Application No: FG/46/20/PL
Site Address: The Tudor Close Public House Ferringham Lane Ferring BN12 5NQ
Description of works: Conversion of the existing Public House (Class A4) to create 7 No residential units comprising 5 No 1-bedroom units & 2 No 2-bedroom units & the erection of 2 No 2-bedroom semi-detached chalet bungalows with associated car parking & landscaping. This application may affect a Public Right of Way.

Thank you for your internet representation made on 14th May 2020 which has been recorded as an objection with the comments as follows:

Drawing Title:
Elevations
As Proposed

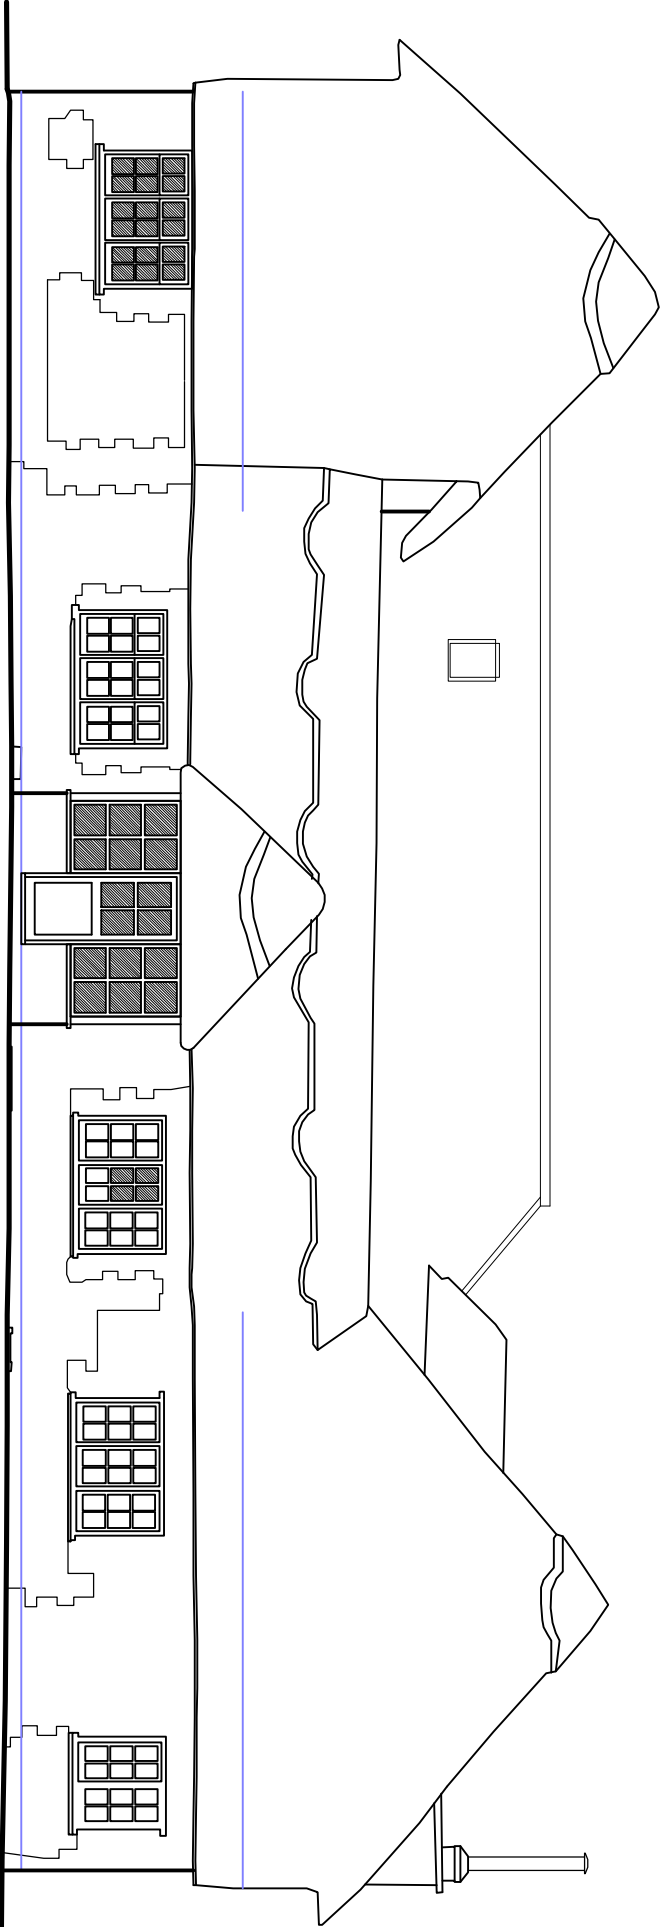
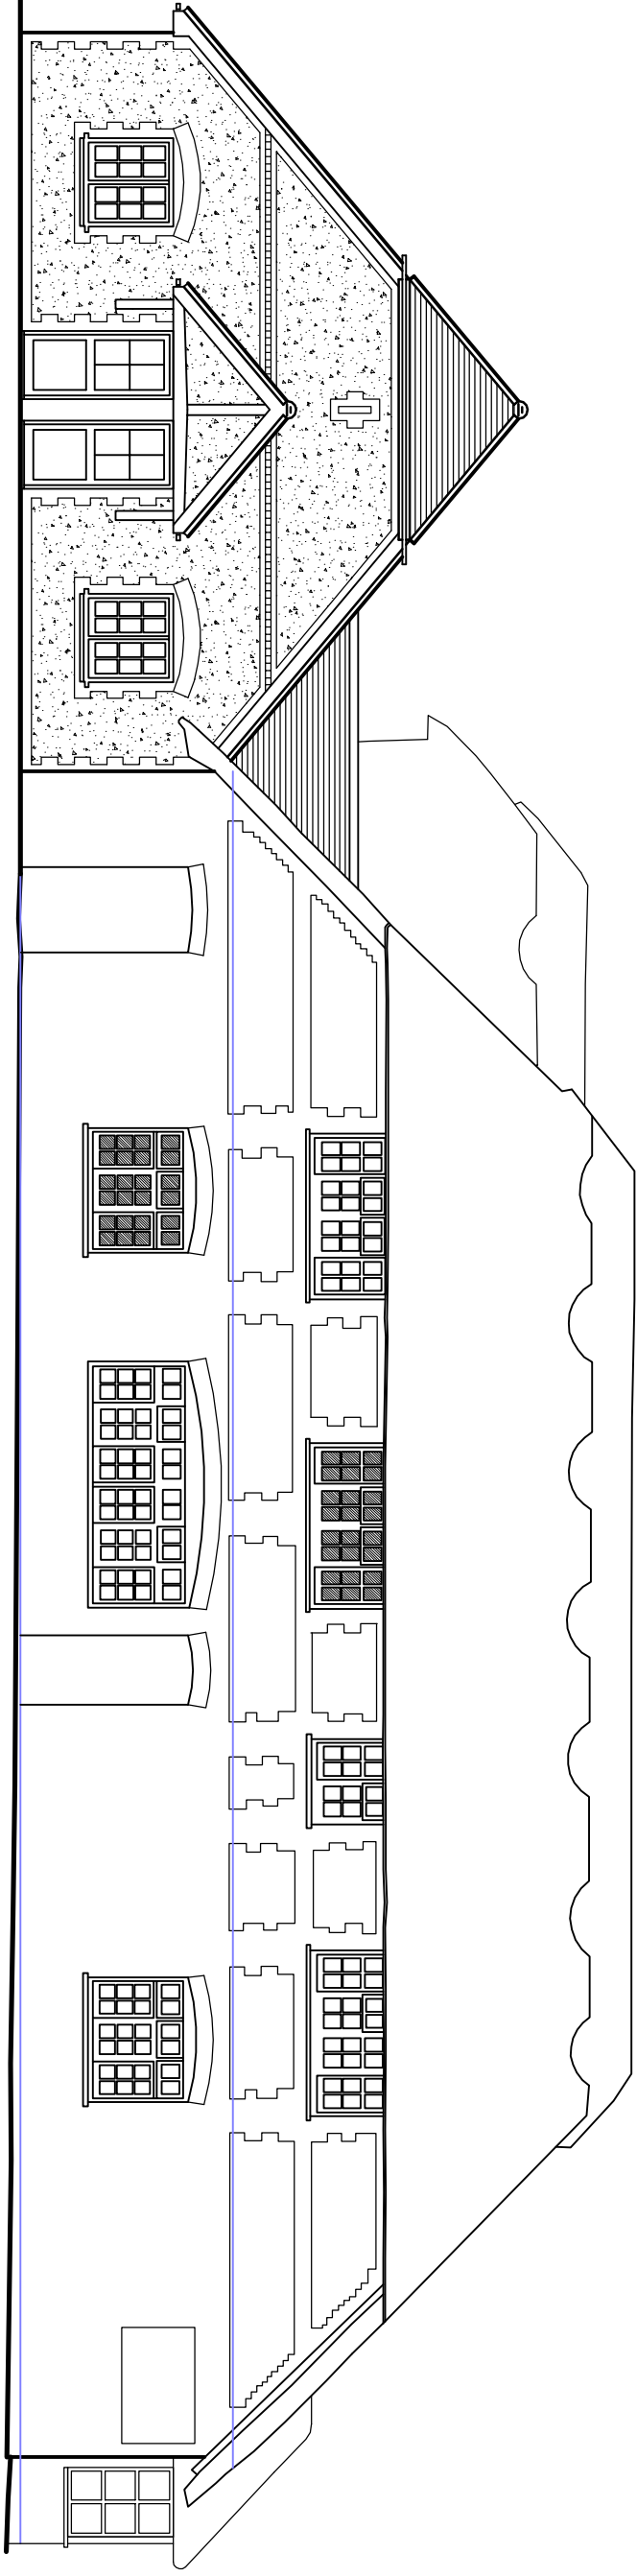
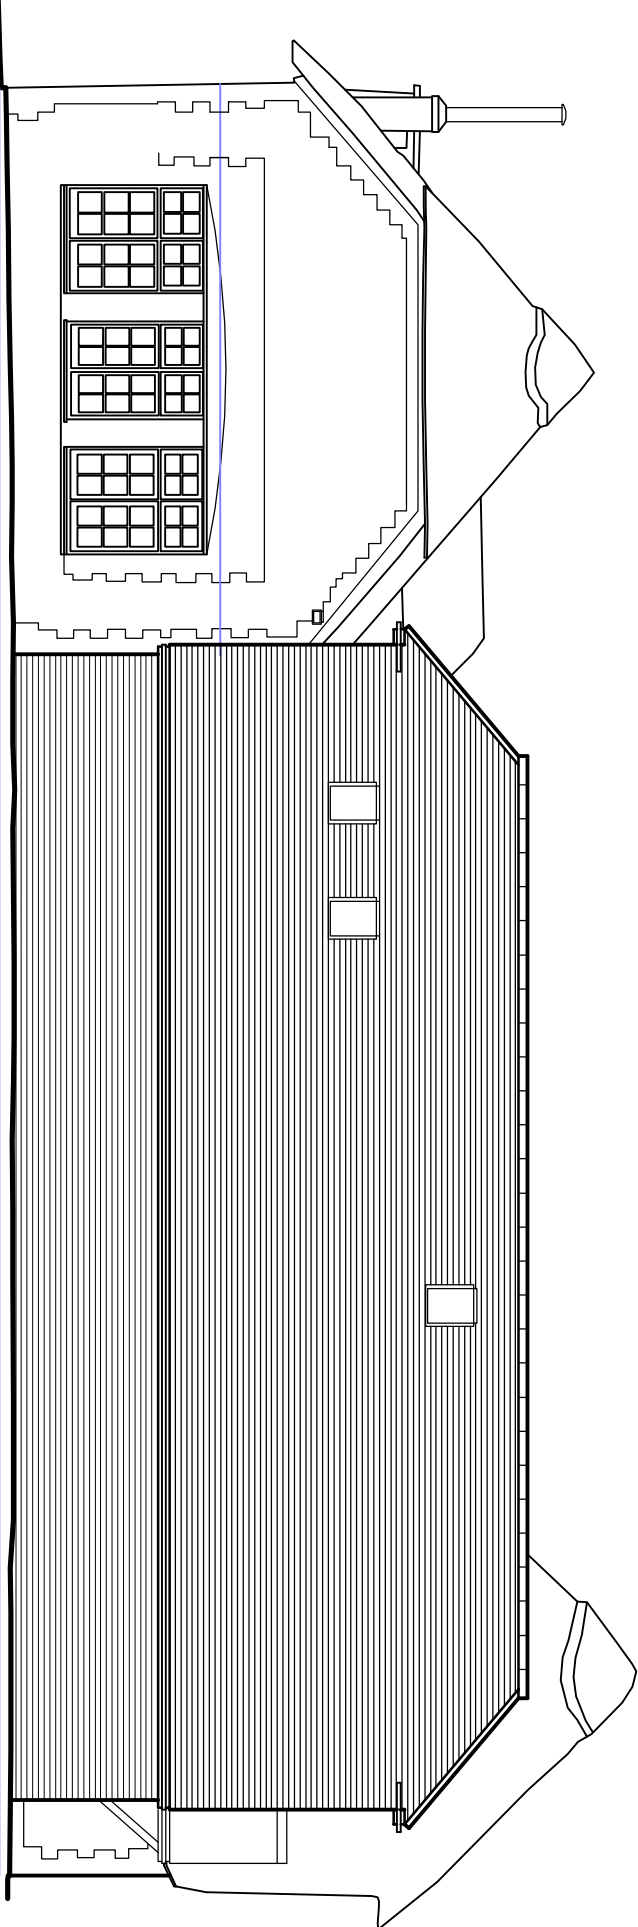
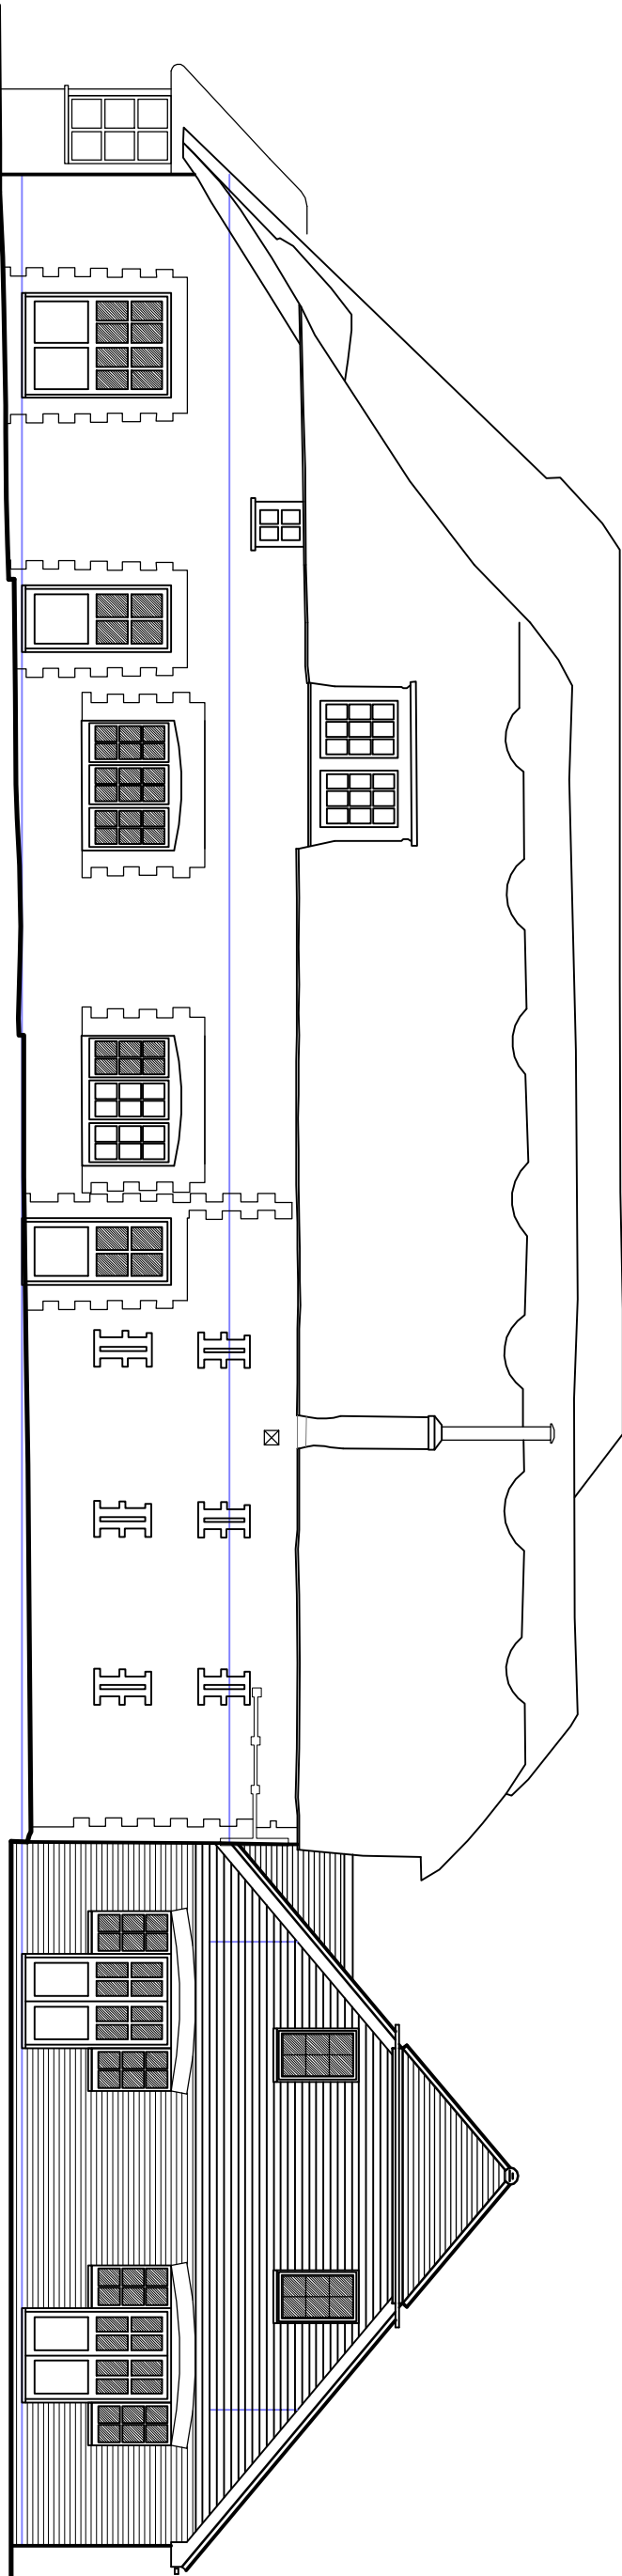
As a resident of Garden Park I will be most directly affected by the building of the chalet bungalows. When our bungalows were built there was a restriction on their height. Therefore I am strongly opposed to the excessive prominence of these bungalows and think that they should conform to the same height as ours. The effect they are proposing will be overwhelming.

I will be looking out from the front of my bungalow at a blank wall and a high roof that will have an impact on the light to the front of my property.

- It is stated that there are no windows on the south side. There seem to be 3 small ones. What sizes are they?
- I need clarification. No measurements are given - No overall height or pitch of the roof is mentioned or the size of the eaves.
- What construction materials are to be used to build the new bungalows? The south side, on the plan, looks

like close boarding. Is that so?
